Road Safety Audit Report

Proposed Roundabout along the A325
Holt Pond

Report Title:	Stage 1 Road Safety Audit
Date:	December 2023
Document reference and revision:	RSA-23-140-4
Prepared by:	Fenley Road Safety Limited
On behalf of the Overseeing Organisation:	Hampshire County Council
Design Organisation:	i-Transport
Project Sponsor:	Haskins Garden Centre

DRAWN	CHECKED	APPROVED
MC	MC	SAW
PROJECT No:	SCALE @ A1:	DATE:
ITB16329	AS SHOWN	12.10.23
DRAWING No:	REV:	
ITB16329-GA-106	E

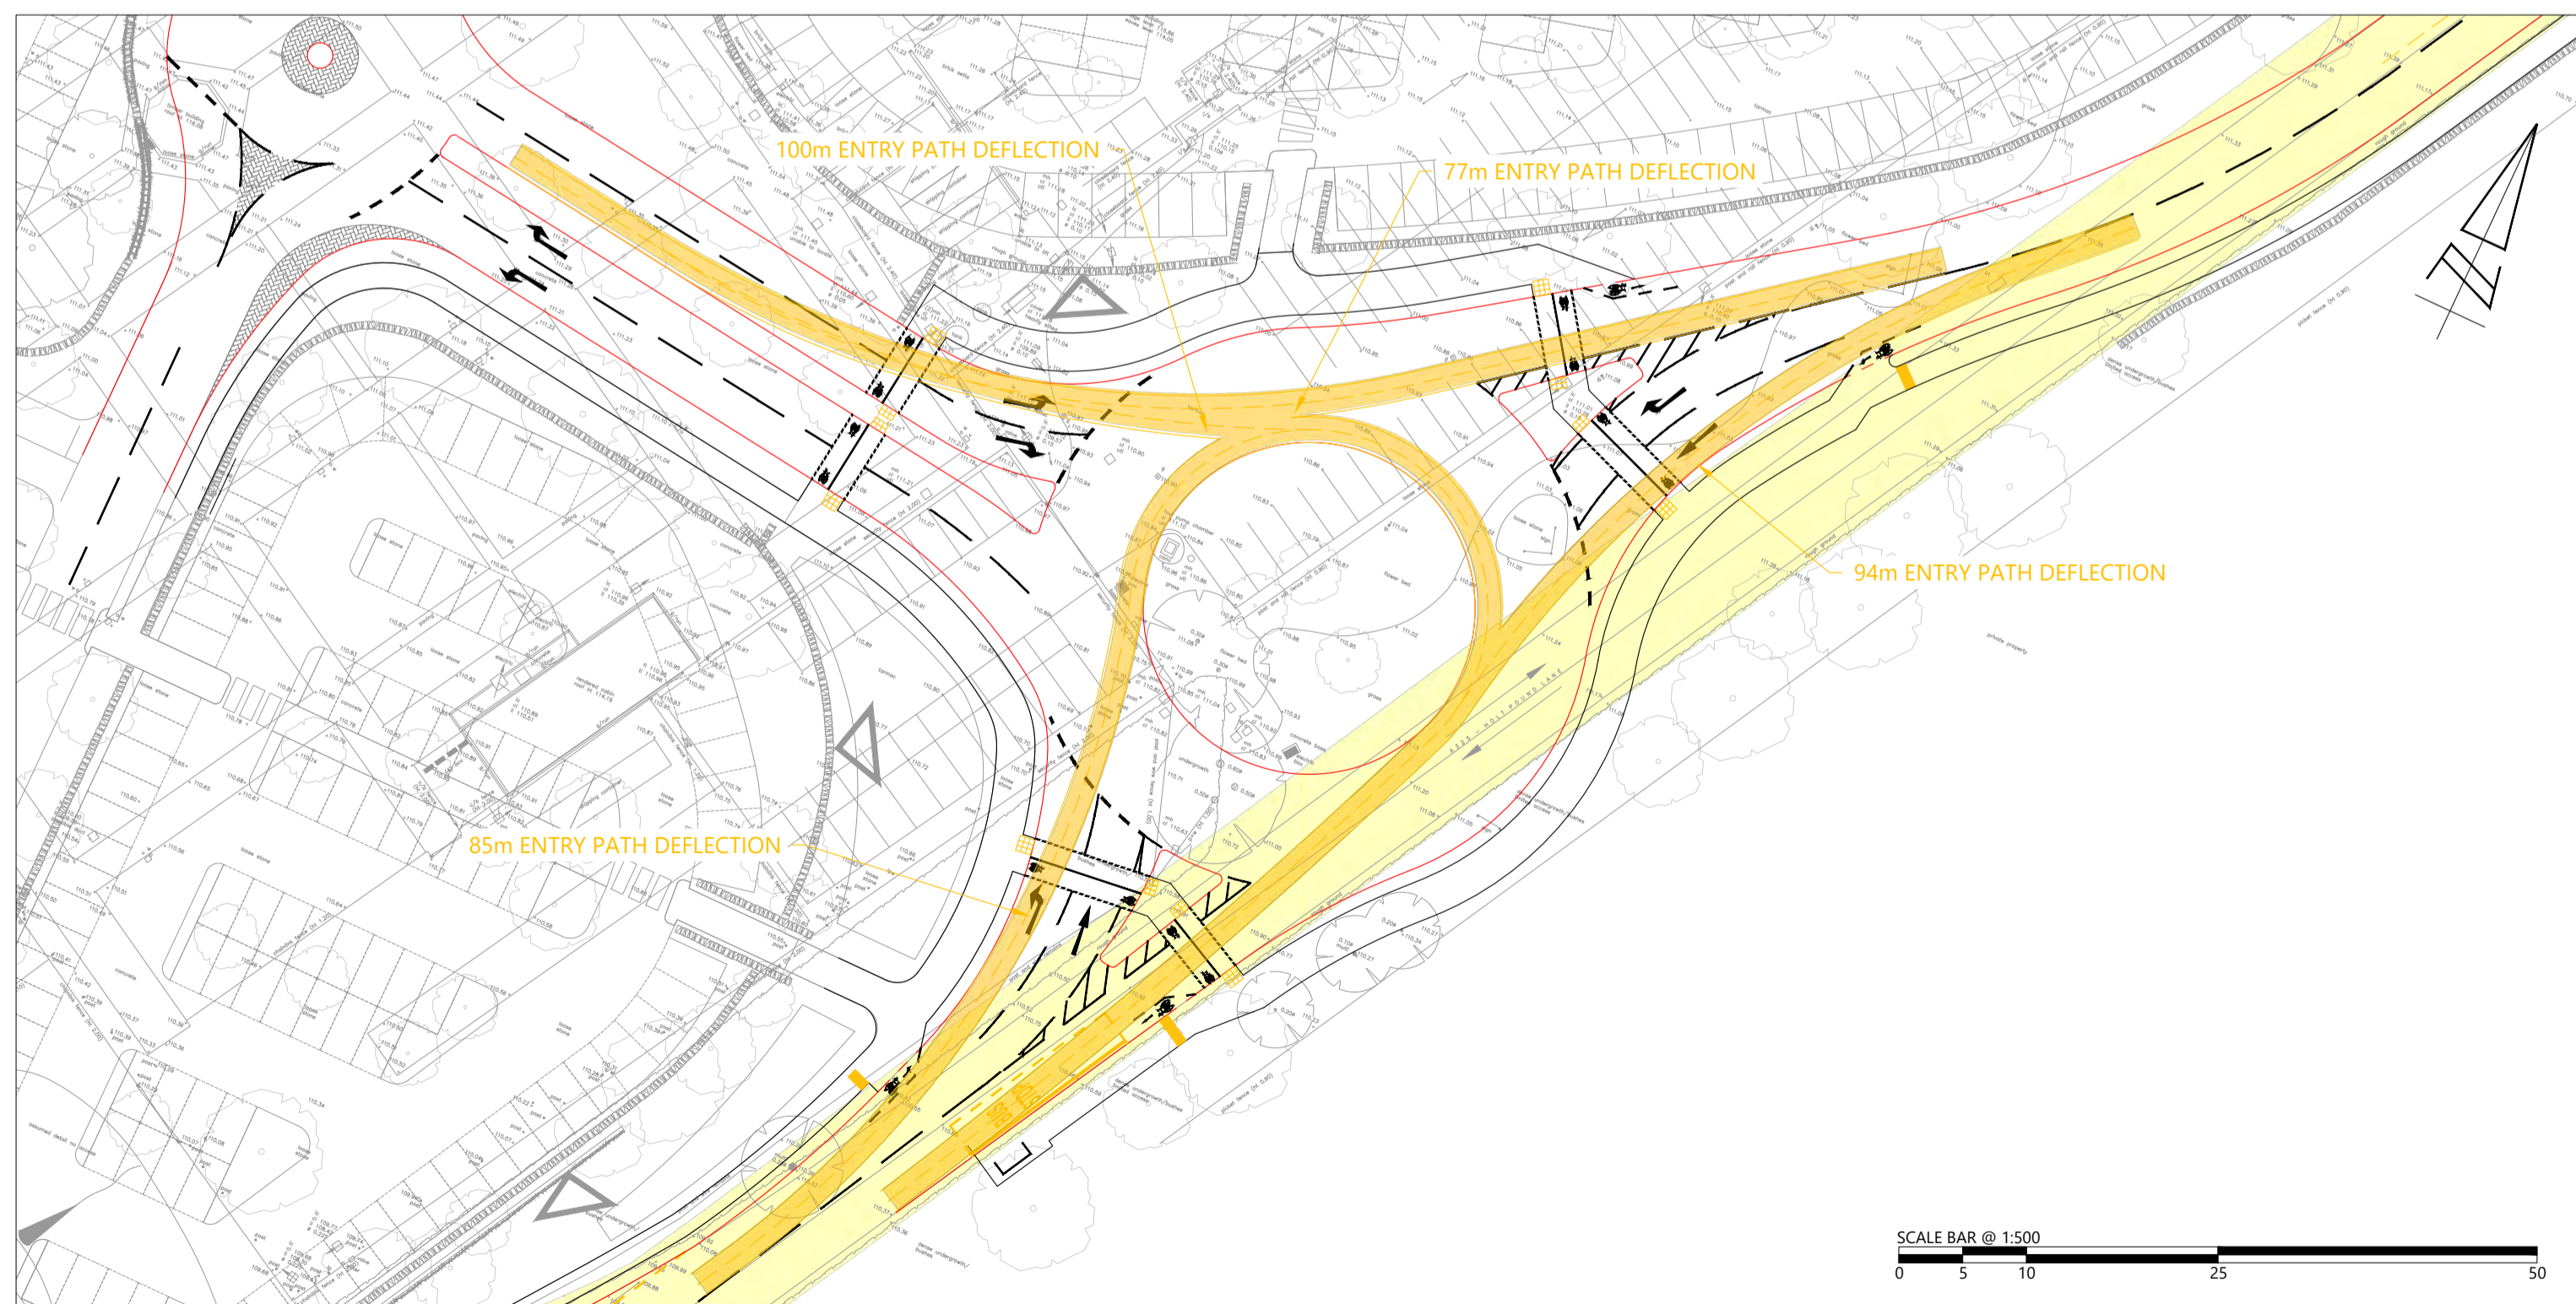
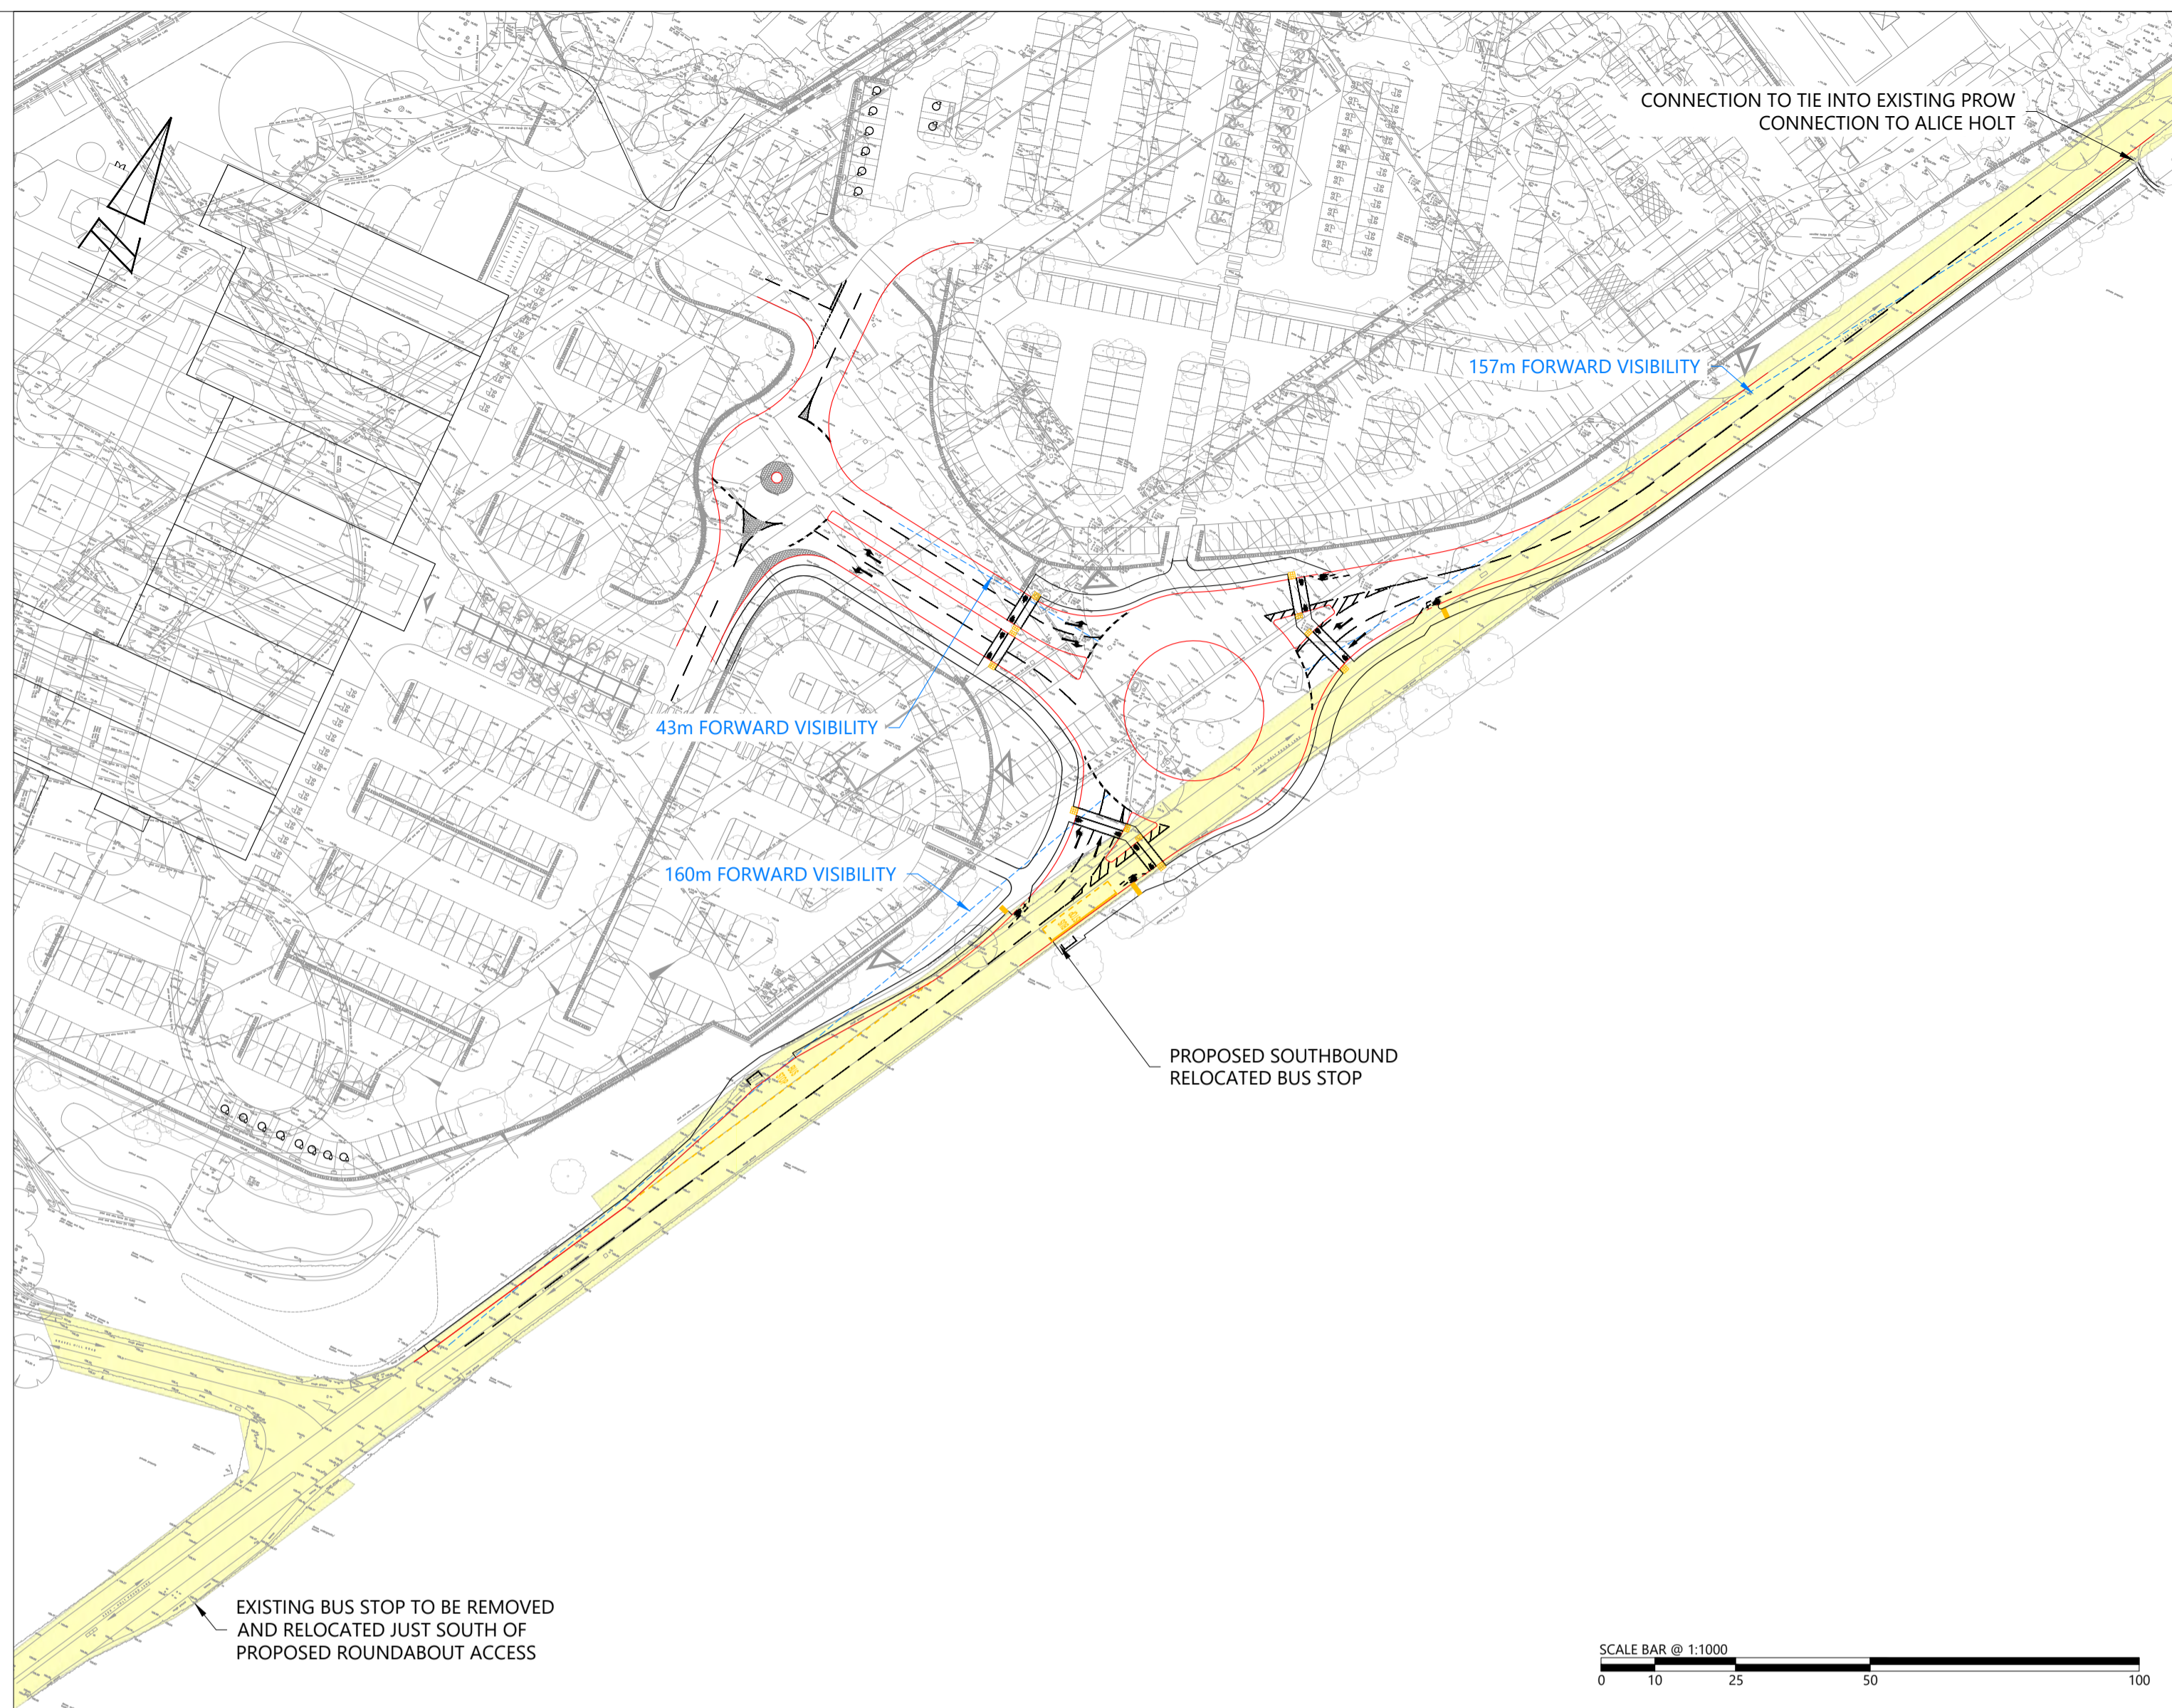
The A325 is straight in alignment, subject to a 50mph speed limit and passes the existing priority junctions associated with the Haskins Garden Centre and Birdworld attraction that are both accommodated within the application site. The proposals include the provision of a three-arm roundabout along the A325 which is to serve a redeveloped Garden Centre and Birdworld. The scheme drawings provided with the Audit Brief identify that a footway is to be accommodated both sides of the development access in proximity of the roundabout. The proposed footway is to extend to bus stops to the south and continue along the eastern side of the carriageway to a public right of way, to the north with uncontrolled crossings provided which benefit from refuges accommodated at the splitter islands on each arm. Whilst the general provision of a footway is

acceptable, the Audit Team has concerns that wind forces generated by large vehicles passing at high-speed, could destabilise a pedestrian leading to a fall and personal injury or vehicle to pedestrian type collisions.

It is recommended that the proposed footway is offset from the carriageway by an appropriate margin.

Agree – The design has been revised to provide a minimum margin of 500mm between the edge of carriageway and footway edge (see Drawing ITB16329-GA-106 revision C).

Confirmation that a margin is to be provided, addresses the road safety concern raised at this stage.
